29 August 2018

**Town and Country Planning Act 1990.
The Town and Country Planning (Development Management Procedure) (England) Order
2015**

RE: 6/2018/1516/COND – Submission of details pursuant to condition 1 (material samples), 4 (listed building details), 5 (roof survey) and 6 (listed fabric protection details) on planning permission 6/2017/2746/LB at Ramada Hatfield St Albans Road West Hatfield AL10 9RH.

Typical nib wall detail
1 : 20

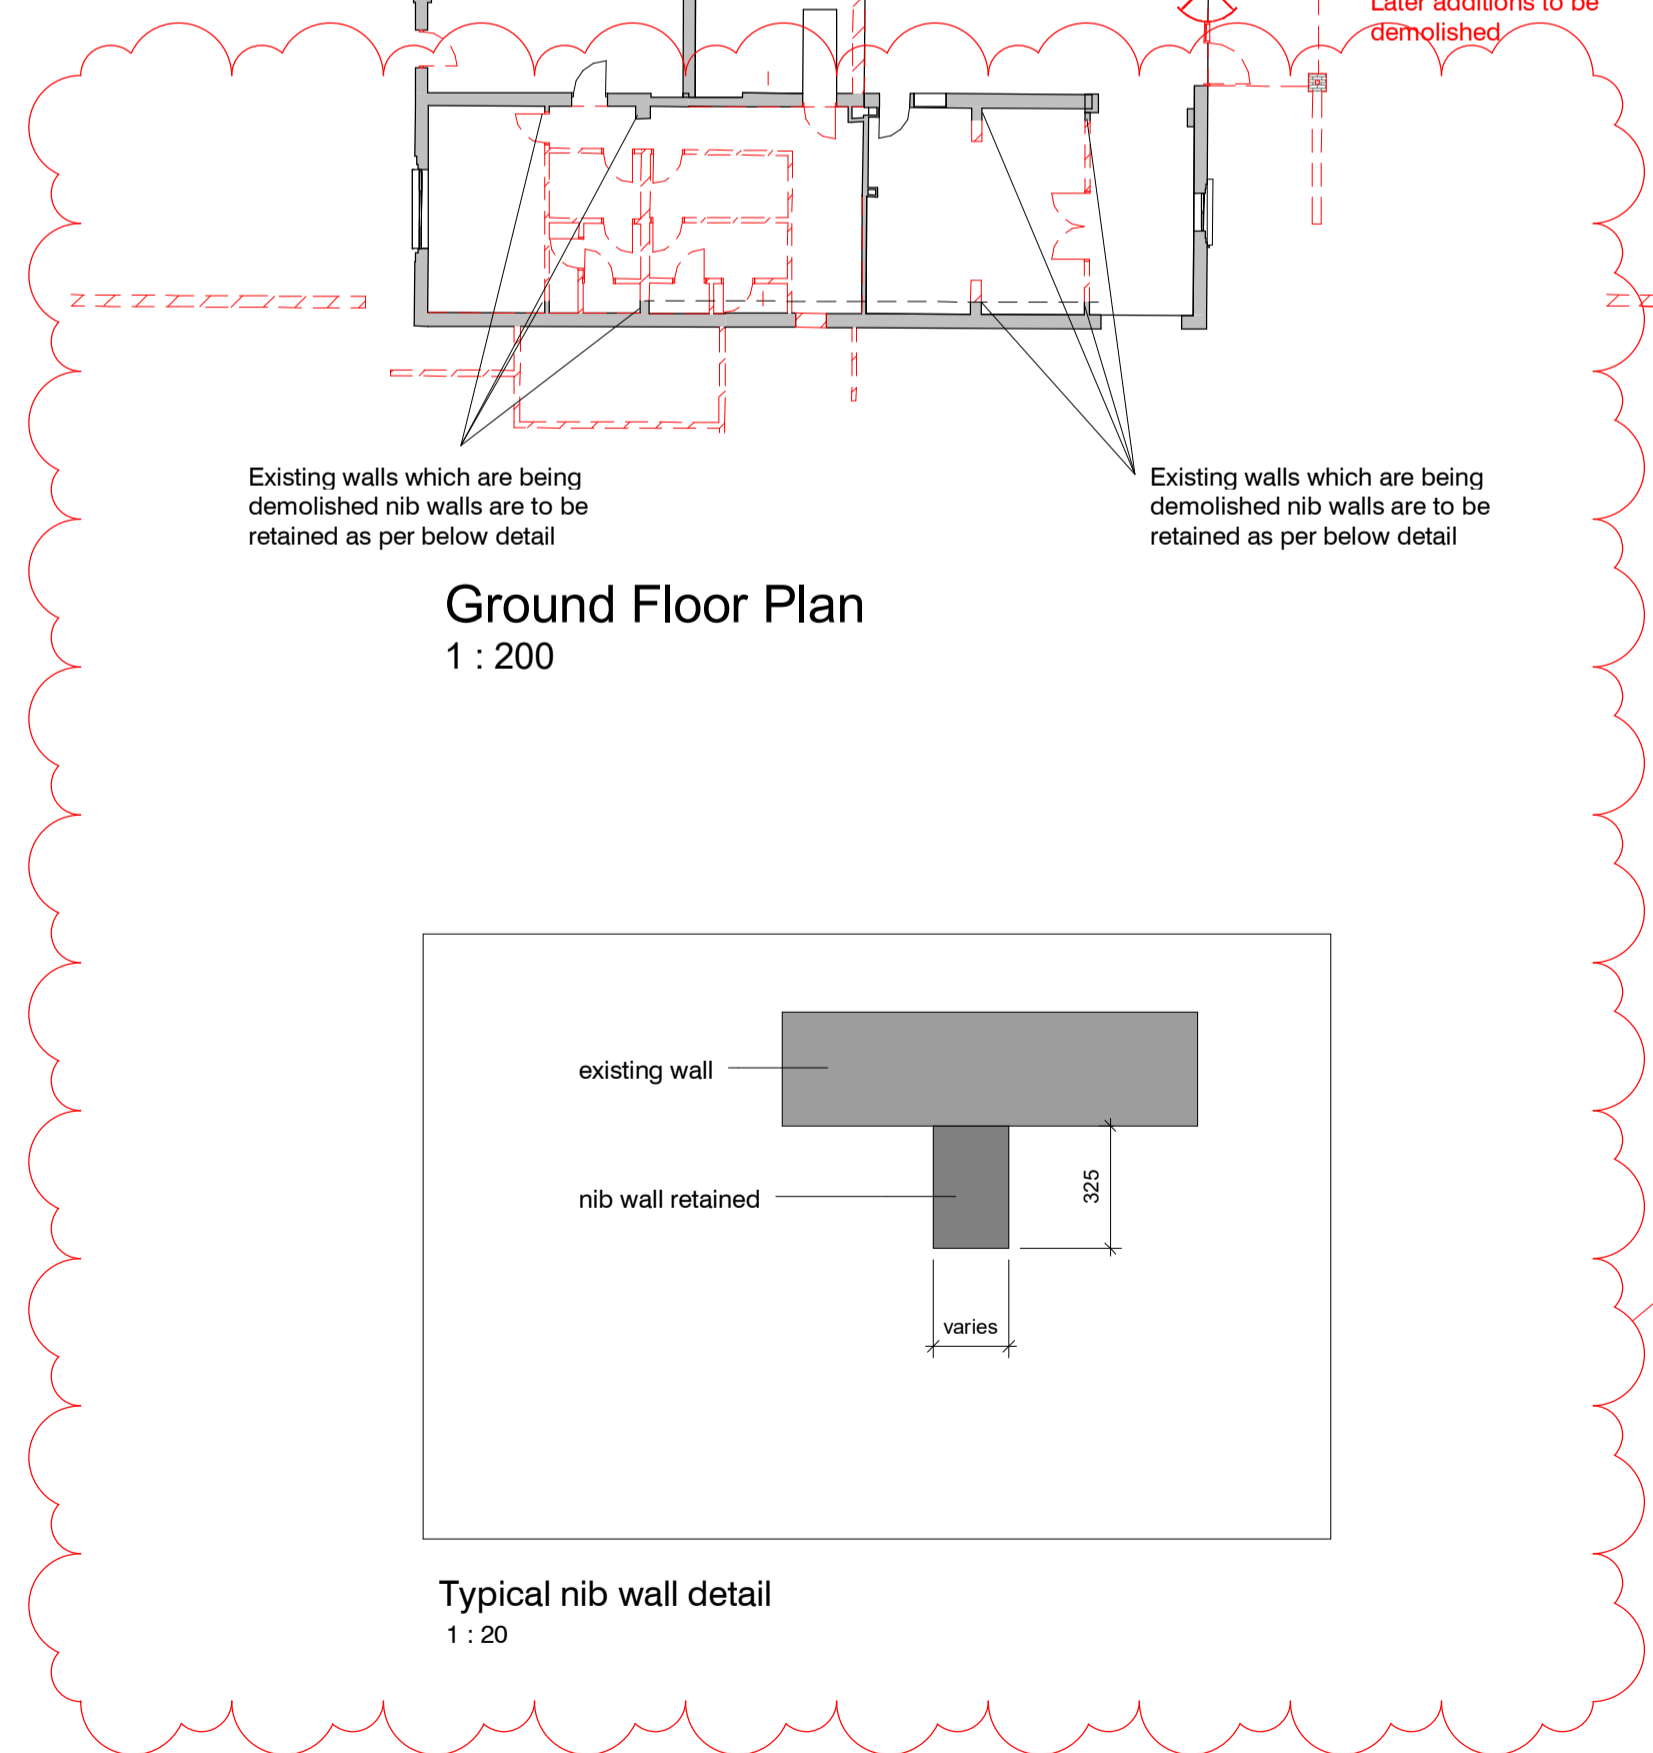
- (b) Drawings Nos COMET-STL-XX-ZZ-DR-A-ZZZZ-46000-C75 and COMET-STL-XX-ZZ-DR-A-ZZZ-46001-C67
- (c) Drawing No COMET-STL-XX-OO-DR-A-ZZZZ-42013-C73
- (g) Drawing No COMET-STL-XX-ZZ-DR-A-ZZZZ-63003-C103

Welwyn Hatfield Borough Council’s Heritage Advisor was consulted on the details. I confirm that the details submitted are sufficient and acceptable for subsections b), (c), (g) of condition 4. The development shall be carried out in accordance with these approved details. Please note this does not include approval of the mortar sample, which is subject to condition 8.
